Rezoning Petition Review

Date of Review: May 20, 2020

Rezoning Petition #: 20-66

RZ-2.0

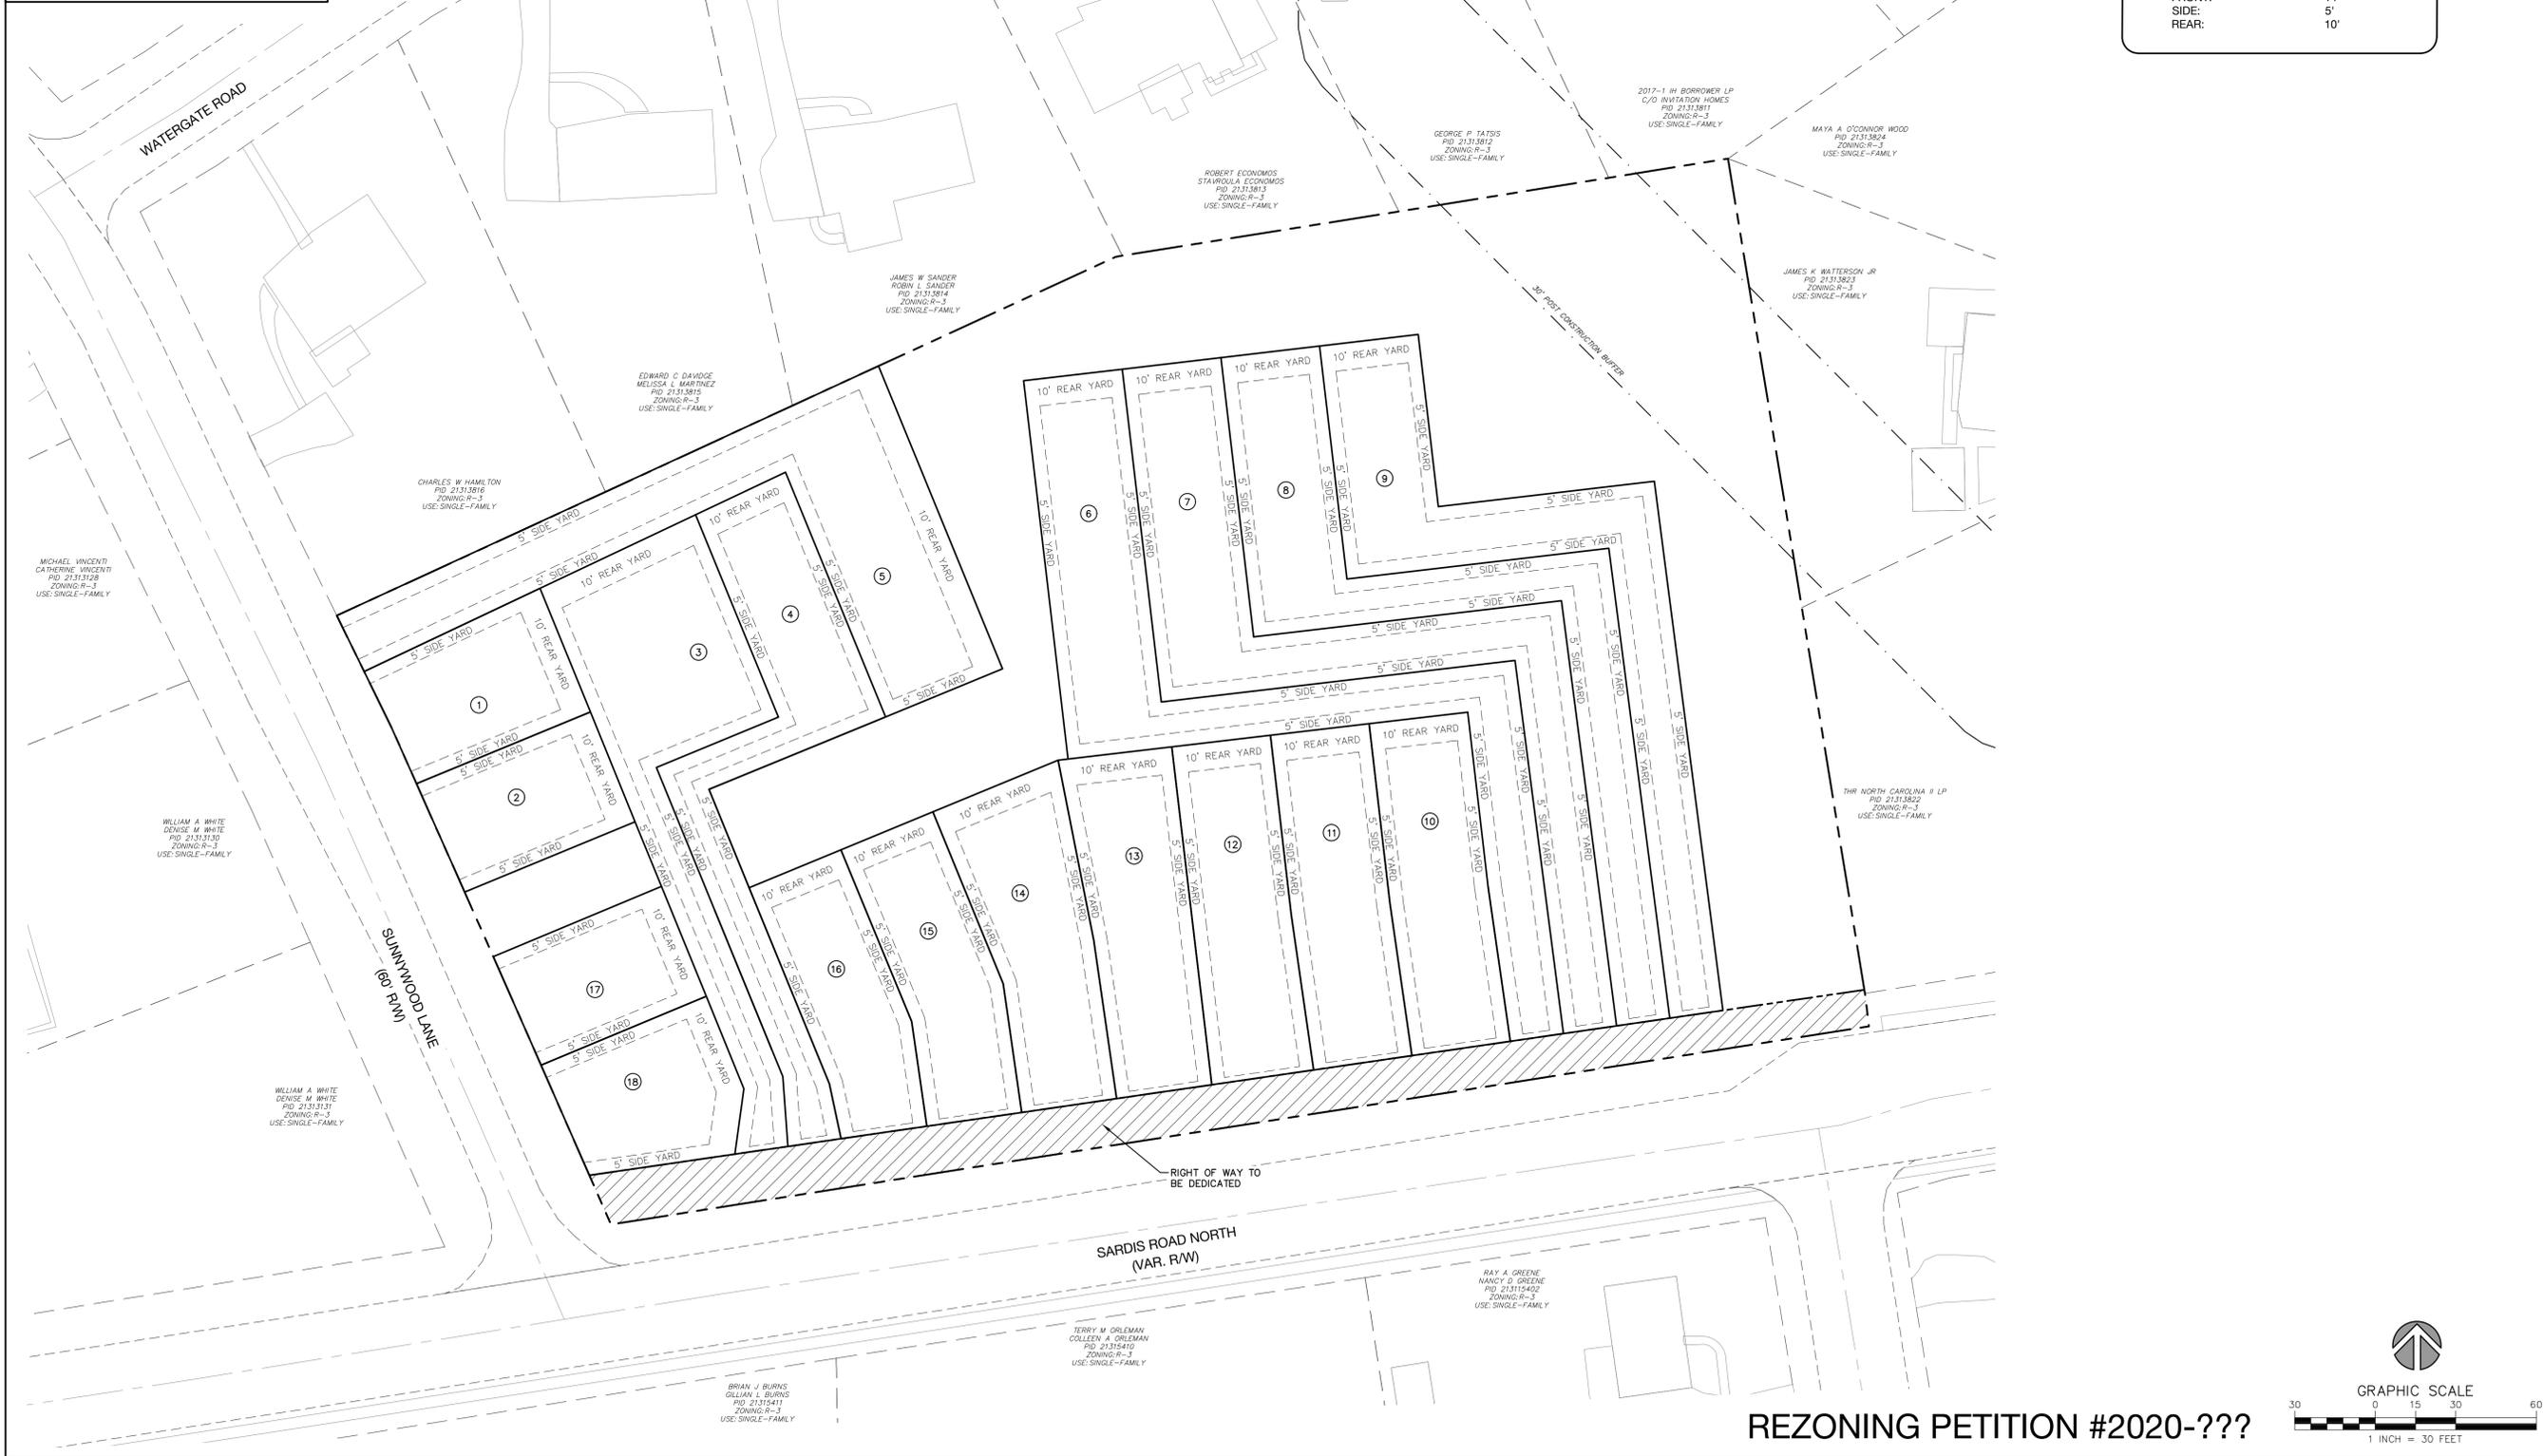
Concerning Storm Water: Please include the following note under Environmental Features:

- *The petitioner shall analyze the adequacy of the existing storm water conveyance on the adjoining parcels to and including Watergate Rd. If the existing storm water conveyance on the adjoining parcels is found to be inadequate, the Petitioner shall make a good faith effort with the property owner(s) to improve the storm water conveyance or mitigate the storm water discharge onto the adjoining parcels.*
- *Development within any SWIM/PCSO Buffer shall be coordinated with and subject to approval by Charlotte-Mecklenburg Storm Water Services and mitigated if required by City ordinance. Petitioner acknowledges intermittent/perennial stream delineation reports are subject to review and approval upon submission of development plans for permitting and are not approved with rezoning decisions.*
